Planning Officer: Michael Eastham

Planning Application Ref: A/38/18/RES

Location: Manor Nursery, High Street, Angmering

Description of works: Approval of reserved matters following outline consent A/51/14/OUT relating to appearance, landscaping, layout & scale for demolition of the existing Manor Nursery Garden Centre & hard standing & redevelopment for 32No. dwellings with associated access, public open space & landscaping

Tree Retention and Protection Plan - Sheet 01
Manor Nursery, Angmering, West Sussex

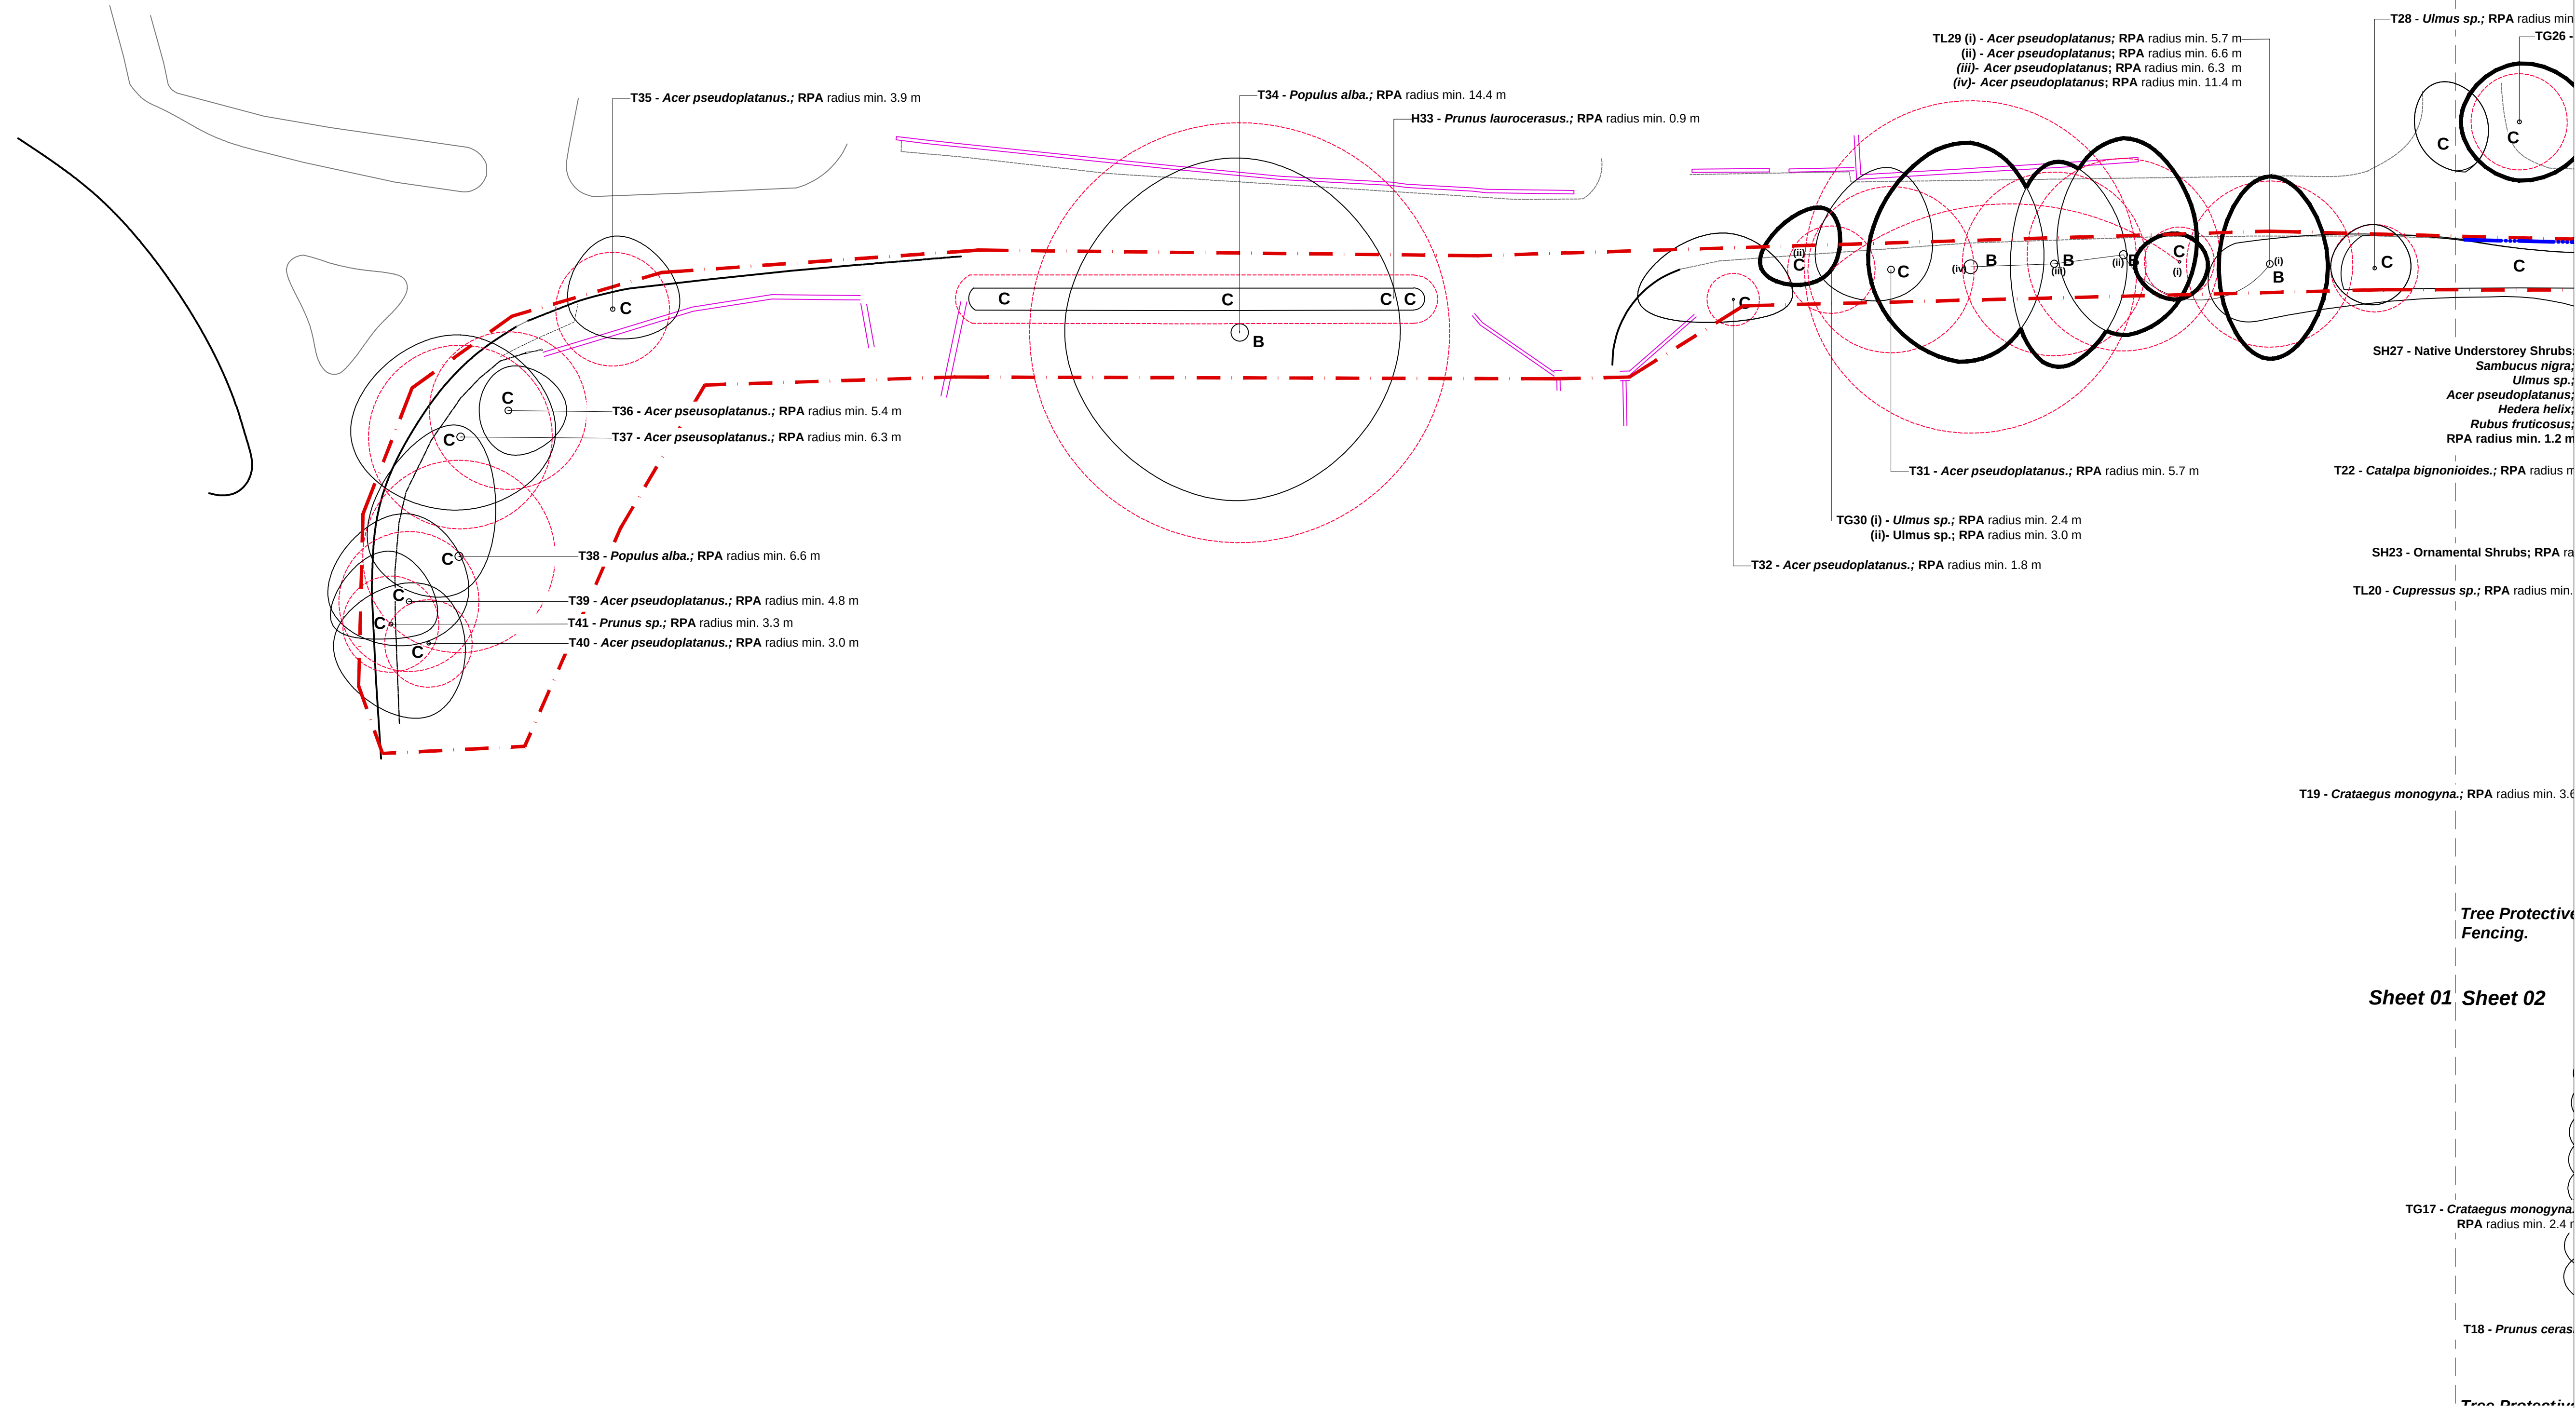
- T07 – lime by virtue of its value and vulnerability to damage demands a clear and ambitious protection plan to ensure it is afforded adequate respect.

- The previous request for a Tree Protection Plan (TPP) which adequately respects this important tree has been met in part, but remains open to interpretation which is unsatisfactory.

- The fencing must be ‘fit for purpose’ and form an effective Construction Exclusion Zone (CEZ) around the RPA which overlaps the development. Any planned incursion into the CEZ for the purpose of removing hard standing must be undertaken in full accordance with existing conditions, namely the advance approval of the Local Planning Authority and preferably under supervision of the project Arboriculturist.

- The TPP (dwg.no LLD1275-ARB-DWG-002, Rev 03) must now be revised to clearly show the line (legend - bold blue) of protective fencing outside of the RPA of T07 and other retained tree RPAs which overlap the development. A revised Tree Retention and Protection Plan (dwg.no LLD1275-ARB-DWG-002, Rev 04) has been submitted and meets these requirements.

In respect of T7 and the proposed manual excavation of hard standing within the RPA, I believe it is necessary to apply an additional condition to ensure the project arboriculturist is actively involved on site before and during this element of work.

- Before the site is occupied or any machinery is introduced to the site or demolition work or construction work or alterations to existing ground levels takes place a **PRE-COMMENCEMENT Site Meeting** is to take place between the Arun DC Tree Officer and the Arboricultural Expert representing the site owners -- at this meeting all protective fencing will be inspected along with any ground protection measures -- they will be assessed to verify that they are 'Fit for Purpose' as required under British Standard 5837:2012 and have been erected and positioned exactly as shown on the **Tree Protection Plan, dwg.no LLD1275-ARB-DWG-002, Rev 04**.
